From: [Jeremy Larson](#)
To: [Chace Pedersen](#)
Subject: RE: ACU-23-00003 Atlas - Notice of Application
Date: Tuesday, August 29, 2023 11:47:37 AM
Attachments: [Design Criteria 818833.pdf](#)

Please find KC CDS Building Department revised comments below for the documentation provided in ACU-23-00003. I missed the portion of the narrative that notes the antennas will be for future lease and are not included in this preliminary design.

SHEET TITLE:
SITE PLAN

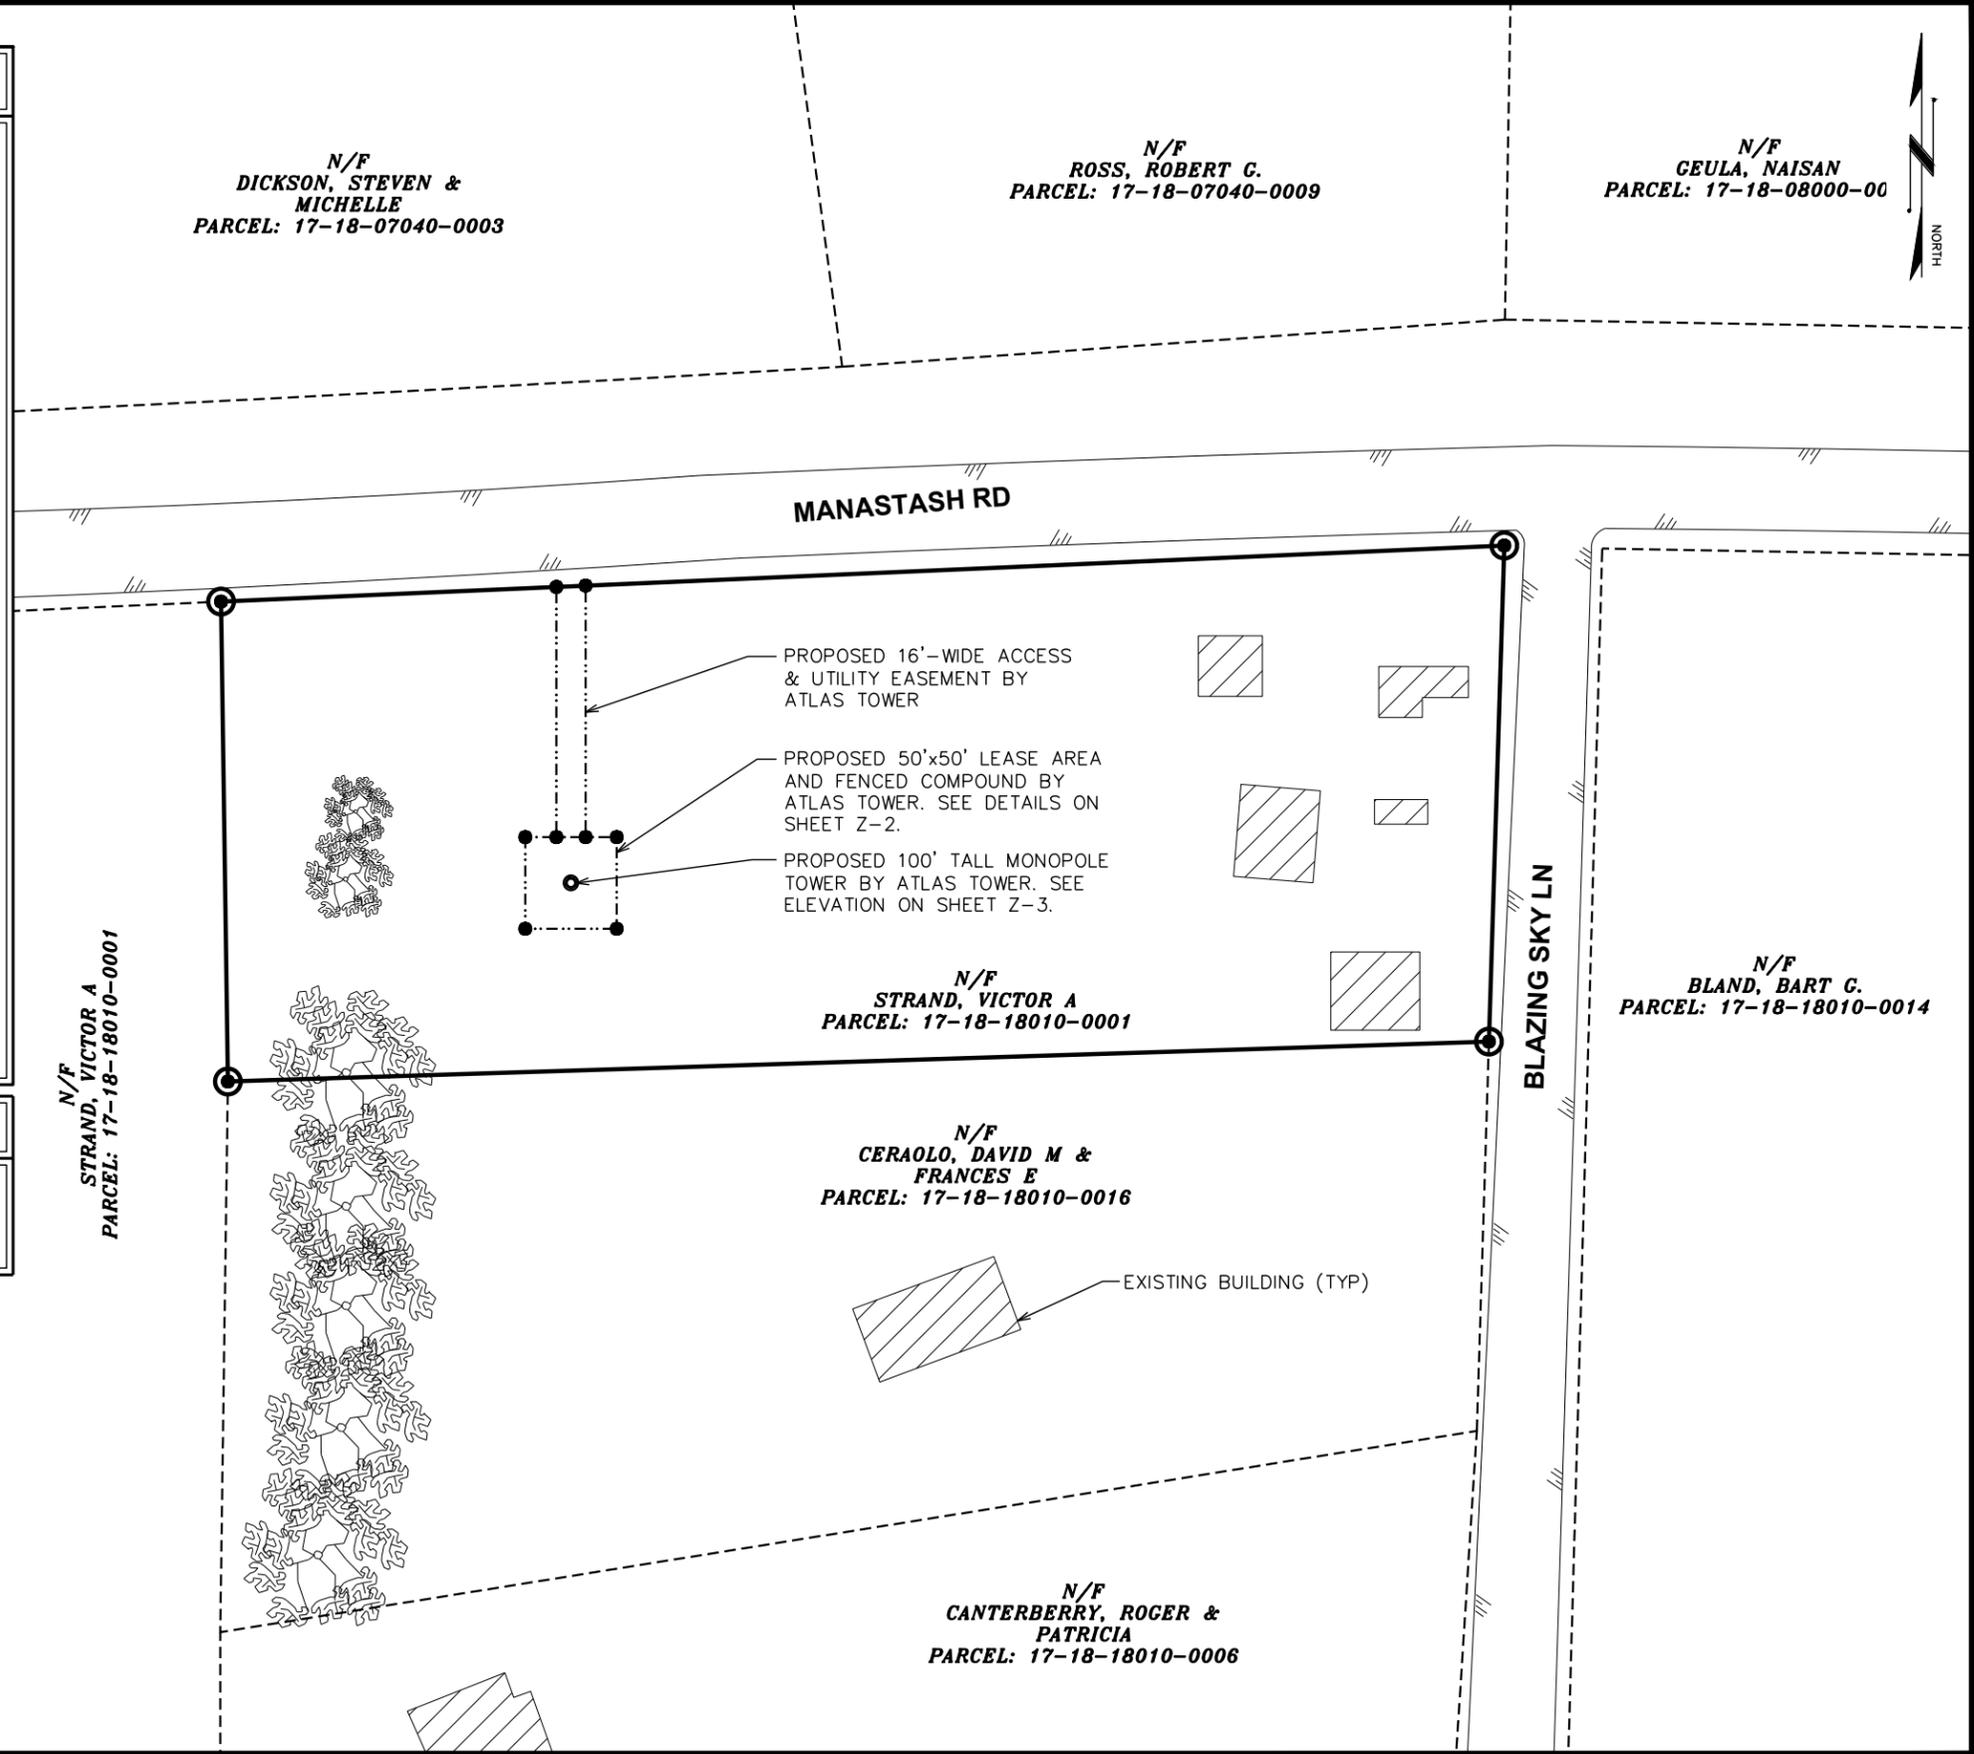
- The antenna needs to be a minimum of 1.2 times the height away from the property line.
- If the fence is over seven feet in height, a building permit will be required for it as well.

TOWER ELEVATION

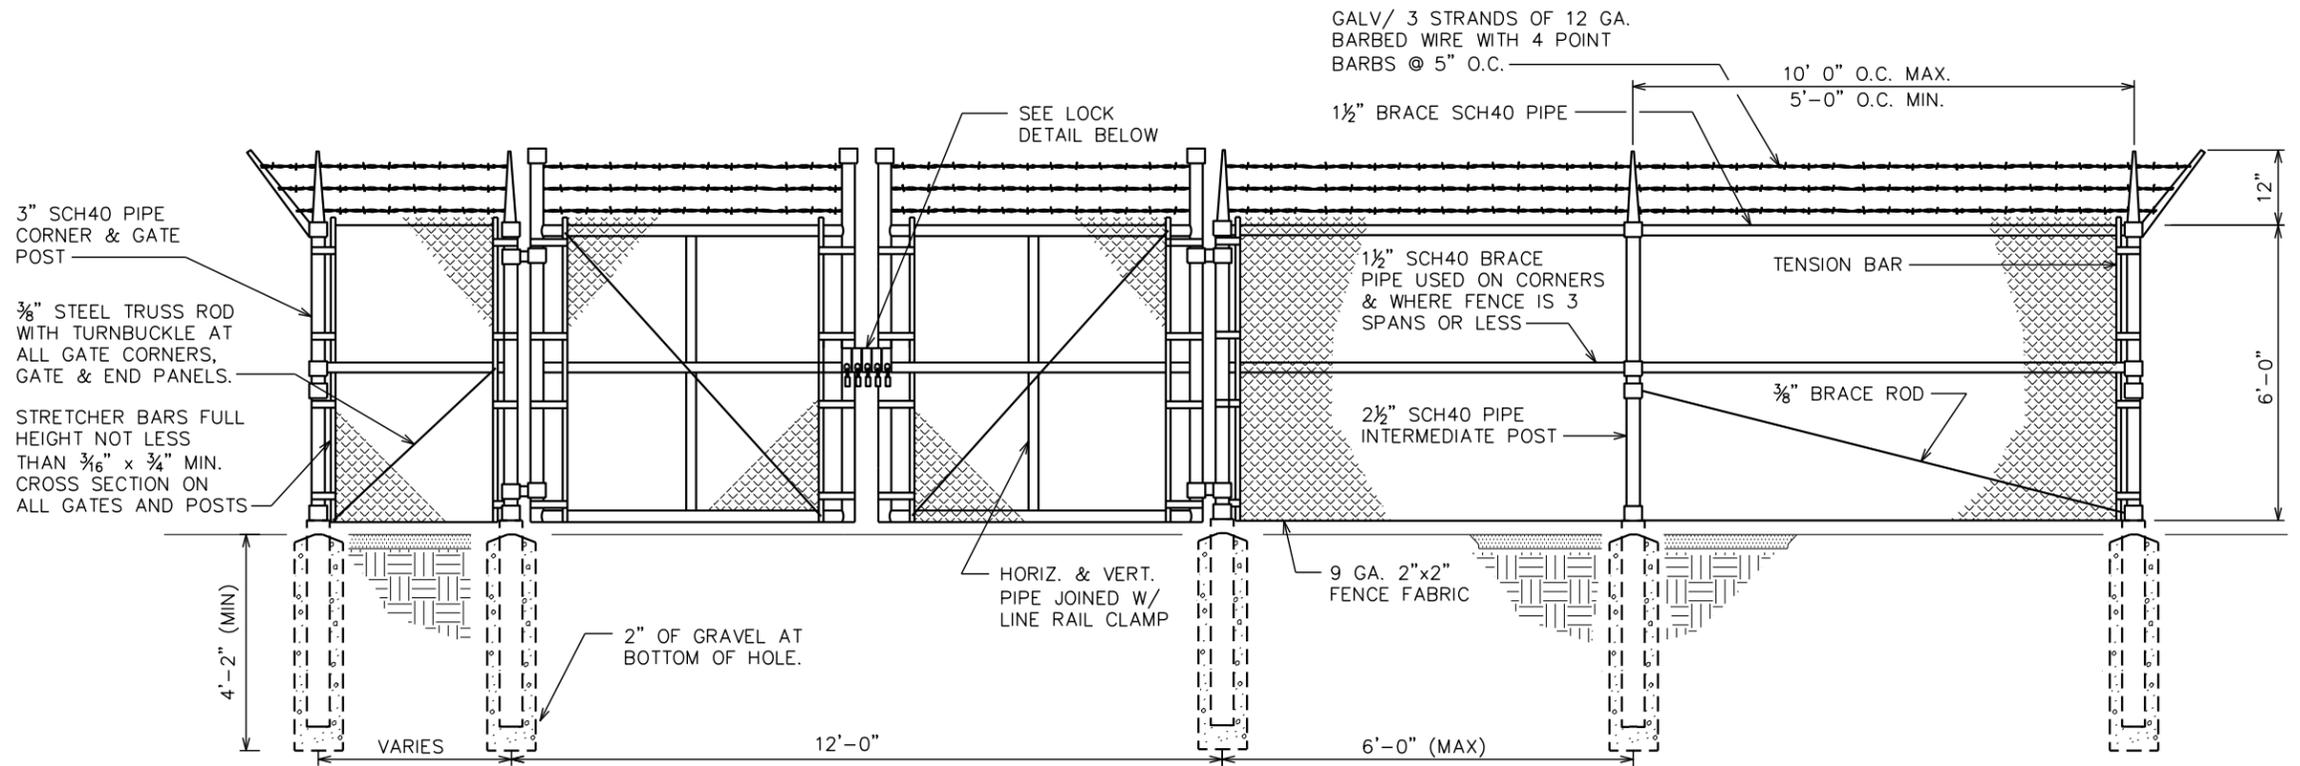
- A building permit is required for the tower and antennas. If the individual antennas are not included in the building plans at the time of plan submission for the tower, additional building permits will be required for installation of the antennas in the future. 2018 IBC section 105.2 does allow replacement of existing antennas without a building permit, but initial installation will require building permits and the tower must be designed to the most conservative requirements for the four (4) antennas.

- The antenna permit documentation will need to include Washington State approved stamped engineer plans and supporting calculations for the footing, attachment to the footing, and the overall structure.
